Submission for the Sydney CBD and South East Light Rail Project Modification 4 -UNSW Stop

1. Objection to the Modification of the UNSW Light Rail Stop to the North of High Street

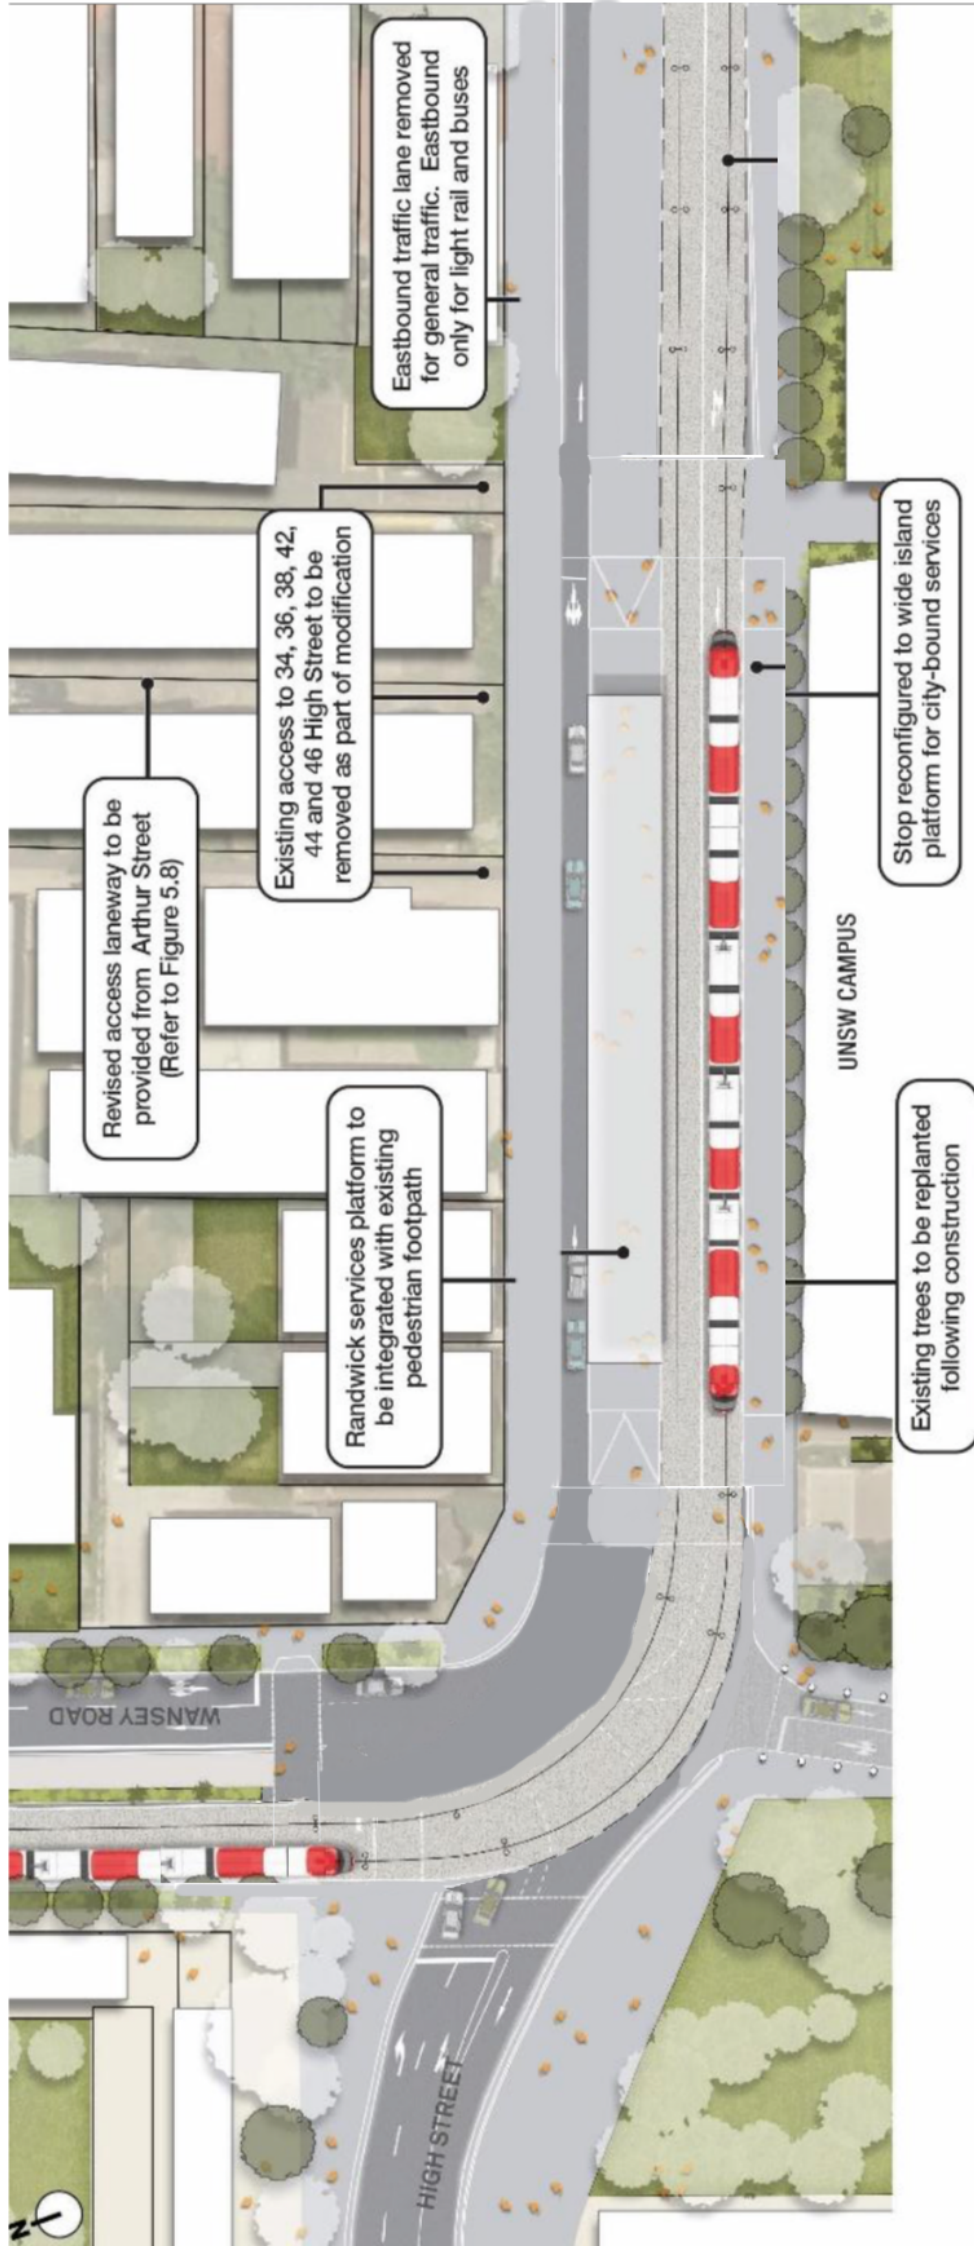
The approved Light Rail plan gave us one way street access. The proposed plan takes this away from us and gives us **shared driveway access** from Arthur Street with four other properties. In our opinion this is **not equitable**. Our property's sole driveway access is being denied us for a poor town planning solution. Our physical address is 38 High Street but the proposed plan is asking suppliers, couriers, visitors, prospective students, High School teachers, short course students, prospective new staff, industry people, sales representative etc. to find us and access us through Arthur Street. Kenvale College's first point of contact for all new parties (customers, suppliers, government agencies etc.) is the administration building fronting High Street. It is also our experience that when people visit the College for the first time they tend to drive to our premises and many, such as couriers, suppliers and sales people only drive. The proposal of **losing High Street driveway access is going to have a commercial impact on our business.**

The proposal provides access to the carpark from Arthur Street. Kenvale College is the primary user of this shared carpark not Creston College. We estimate that we will **lose at least five carparks** with the two vehicle access points into this carpark as outlined in the plans. One of these carparks is the front parking bay on High Street. This carpark will become redundant as it will be very difficult to turn around given the proximity of the Light Rail platform and thus a driver's only recourse will be to reverse down the long driveway either on entering or leaving the carpark. The Light Rail will be very beneficial for most of our students, however most of our staff are part time and are currently working in the industry and they have other commitments on the day they teach at Kenvale. **We have been able to attract and retain very good lecturing staff because we have carpark facilities.** Some of our teaching and administrative staff live locally, are part-time and have young children and have chosen to work at Kenvale because of the convenience of driving to work since we provide a carpark. The loss of carparks is going to have human resource implications and most likely commercial operational impacts.

The proposal indicates that the Arthur Street lane way will be 6 meters wide. We have commercial teaching kitchen with daily food deliveries, deliveries for an operational teaching bar, trades people on the premises nearly daily, commercial cleaners early in the morning and many other service vehicles frequenting our premises. We expect NSW Transport to **ensure that two trucks can drive on this lane simultaneously**. Currently we have one lane access but we have a parking bay and we control entry and access of vehicles. We lose this control with driveway access on Arthur Street.

In our consultation meetings with NSW Transport it was mentioned that Randwick City Council will not drive into the Arthur Street lane to collect the rubbish of 36, 38, 40, 42, 44 High Street. **We suggest that NSW Transport demands that the garbage trucks come to the hammer head as indicated in the proposal**. We suggest that both NSW Transport and Randwick City Council take a drive along High Street early on a Monday morning and count the number of garbage bins from these properties. They will soon see that it will be physically impossible to put all those garbage bins on Arthur Street near the lane way.

We would also like to suggest to NSW Transport to consider **moving the two platforms 40 meters east** so the actual platform is not in front of our commercial educational premises. We acknowledge we will not have driveway access with this proposal but at least we will retain our building street frontage with less interference from a Light Rail platform.
